Engineers Comments Regarding Surface Water Drainage

Application Reference:	CM/6/24/DOC	Reviewer Reference:	ADC/EXT12/GK
Planning Officer:	Jessica Riches	Date of Review:	01.10.2024
Site Name:	Land to the West of Church Lane and South of Horsemere Green Lane Climping		
Application Description:	Approval of details reserved by condition imposed under CM/1/17/OUT relating to conditions 6-Phasing Plan and Programme , 8-Arboreal Method Statement, 9-surface water drainage scheme, 10-discharge of flows to watercourses or the culverting, diversion, infilling or obstruction of any watercourses on site , 11-Flood Management and Mitigation scheme, 12-Ecology Management and Mitigation Plan, 13-archaeological works, 14-Constuction Method Statement, 15-Travel Plan, 16-energy efficiency measures, 17-acoustic barrier, 21-Employment and Skills Plan and 22-provision of broadband.		
Assessment Number:	2 of 2

NoApplication Reference: CM/6/24/DOC	Initial Issue Date:
Site Name: Land to the West of Church Lane and South of Horsemere Green Lane Climping	Issue Date: 02/01/2024
	Reviewer Reference: ADC/EXT12/GK

Drawing Code: 000-BPC-WD-ZZ-D-C, Drawing No: D492, Rev: -

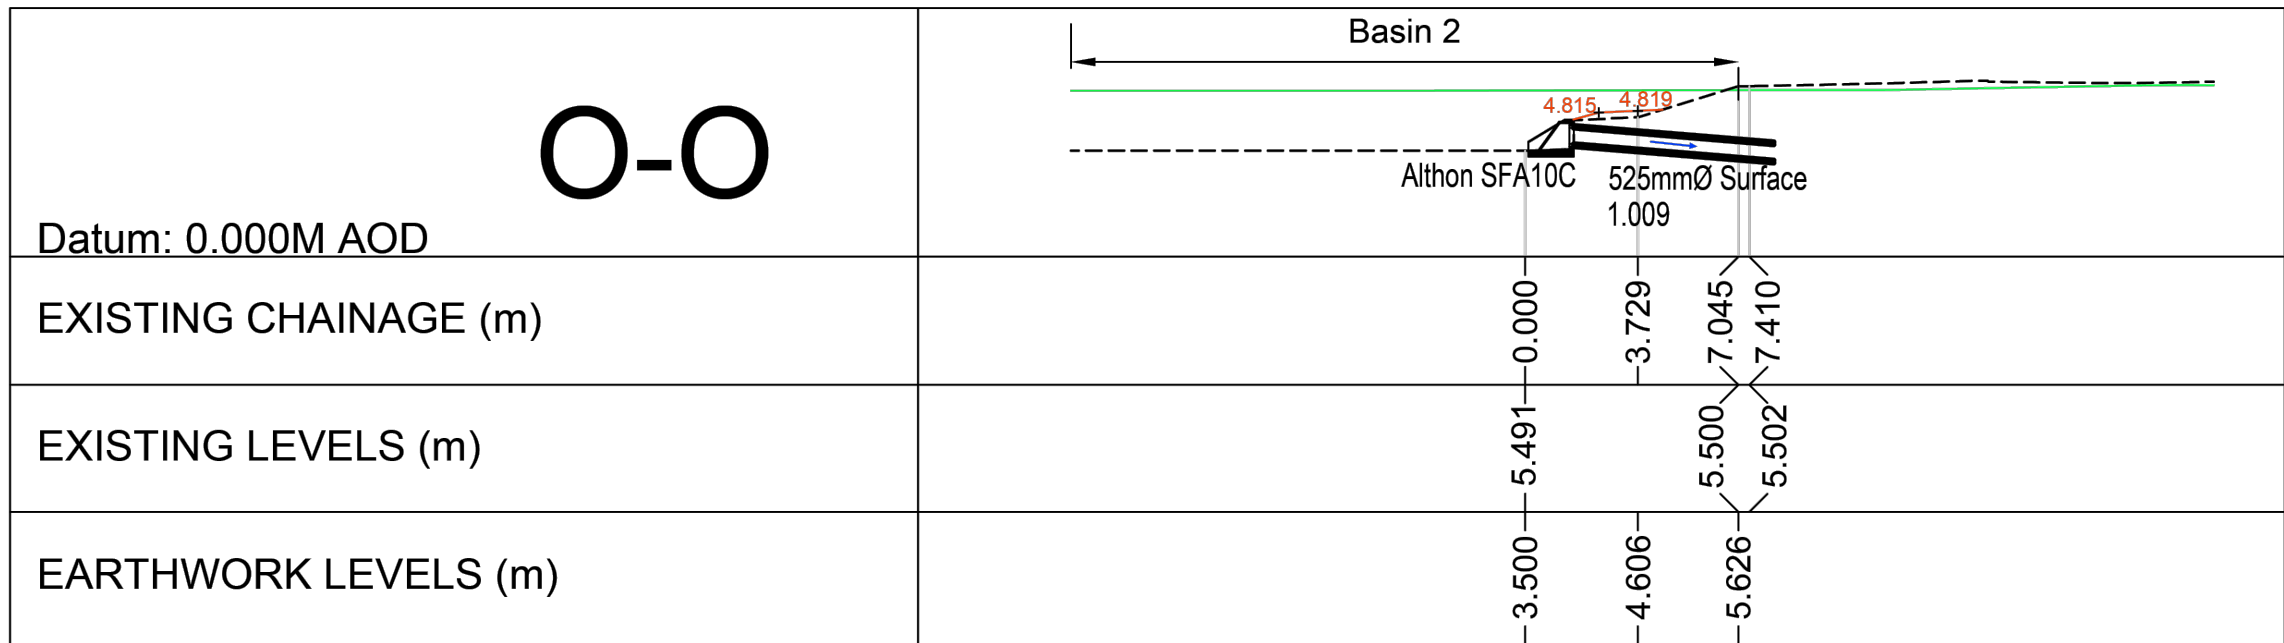
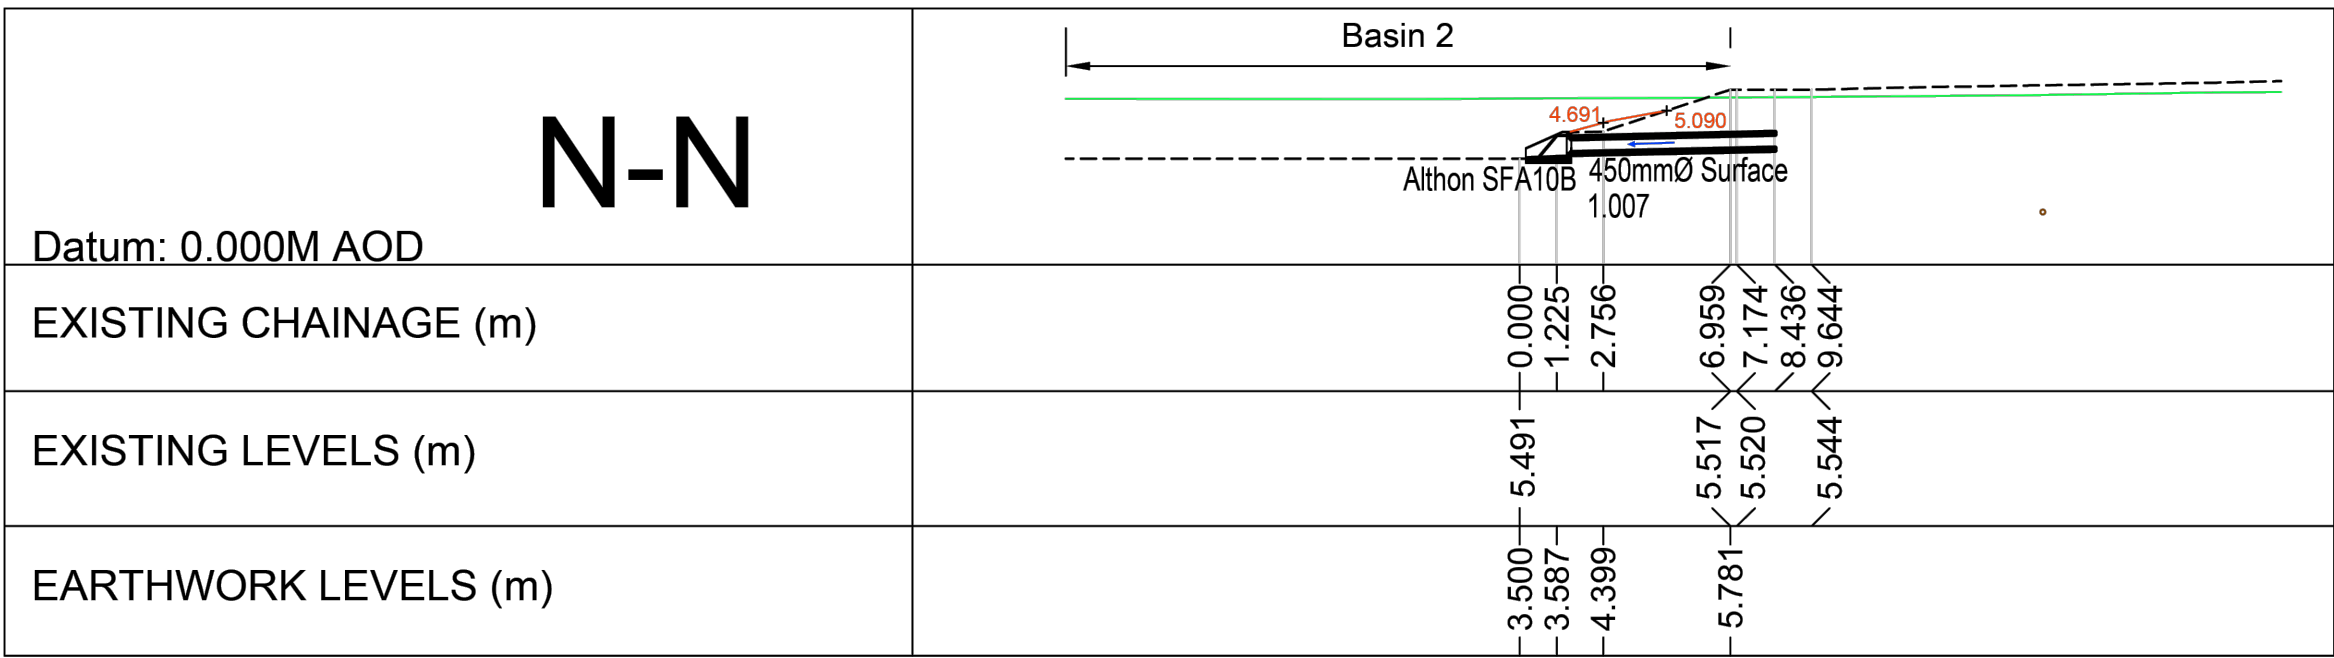
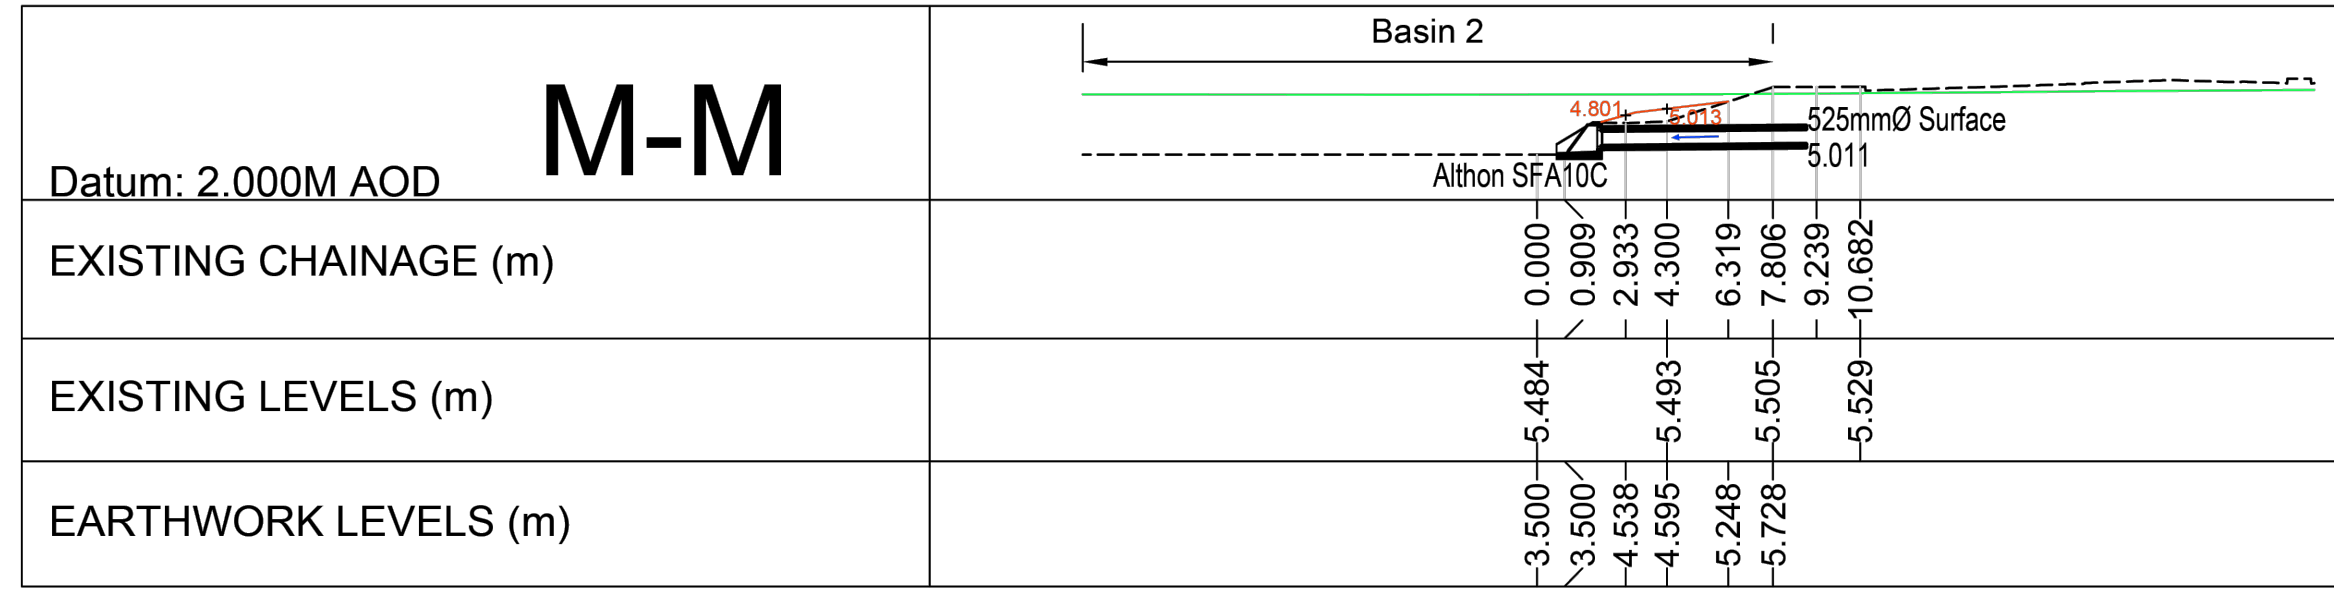
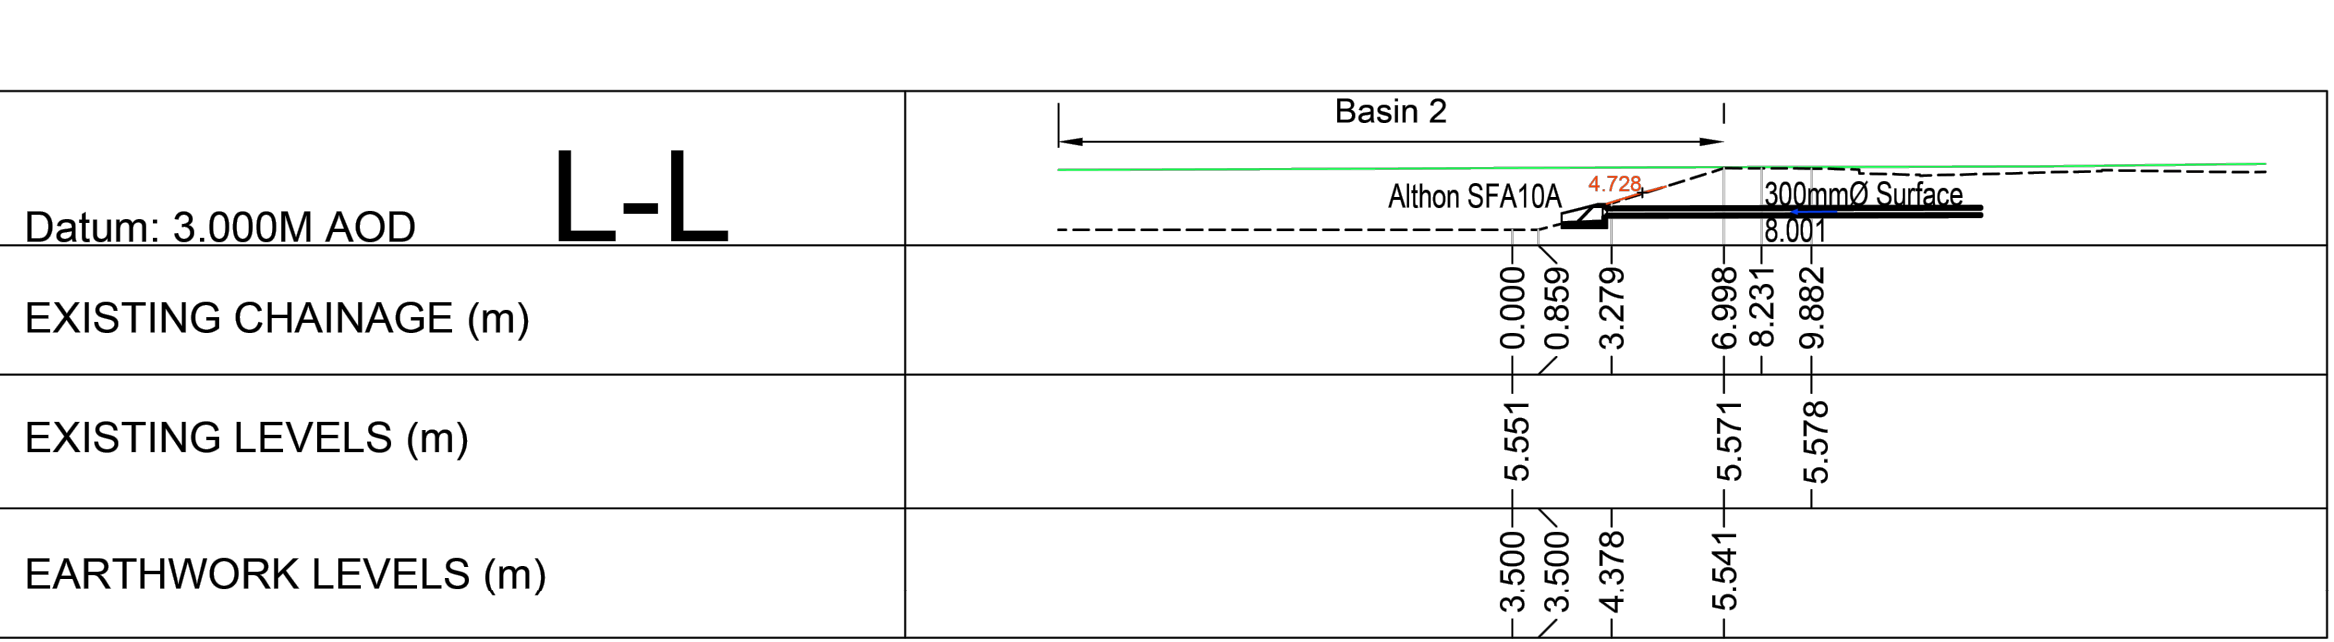
11.	No drainage details have been provided, all materials and structures are to have details provided including control devices.	No comments – refer to updated design.	Headwall details have been provided but they are generic. Each headwall should contain the outfall IL, the basin level, the pipe size and the earthworks details. There have been submitted typical details of the swale but detailed design details are required. Please provide detailed construction details for all the attenuation tanks. Also, include the road/footpath detail above where applicable.	Refer to headwall sections plans - FOR-E5139-482 to 485. Altho specific headwall details are shown on these plans. The sections shown on the plans give specific information for how the headwalls tie-in with surrounding earthworks and base of basins

16.	A new water course is proposed along the northern site boundary. Is this just a conveyance swale for the onsite system or does this receive flows from anywhere offsite? There is no mention of this in the FRA. It is noted that the side slopes are 1:2 these should be reduced to 1:3 as it is noted that the ‘swale’ is up to 1.9m deep in some places.	No comments – refer to updated design.	Comment remains.	This is a proposed swale for conveying flows from the proposed site. SI works done by G and W encountered groundwater at 1.5m bgl in the road south of the swale. The swale is proposed as a conveyancing feature and will not infiltrate into the ground. Swale banks shall be 1:3 with a granular sub-base. For the swale levels refer to FOR-E5139-492.
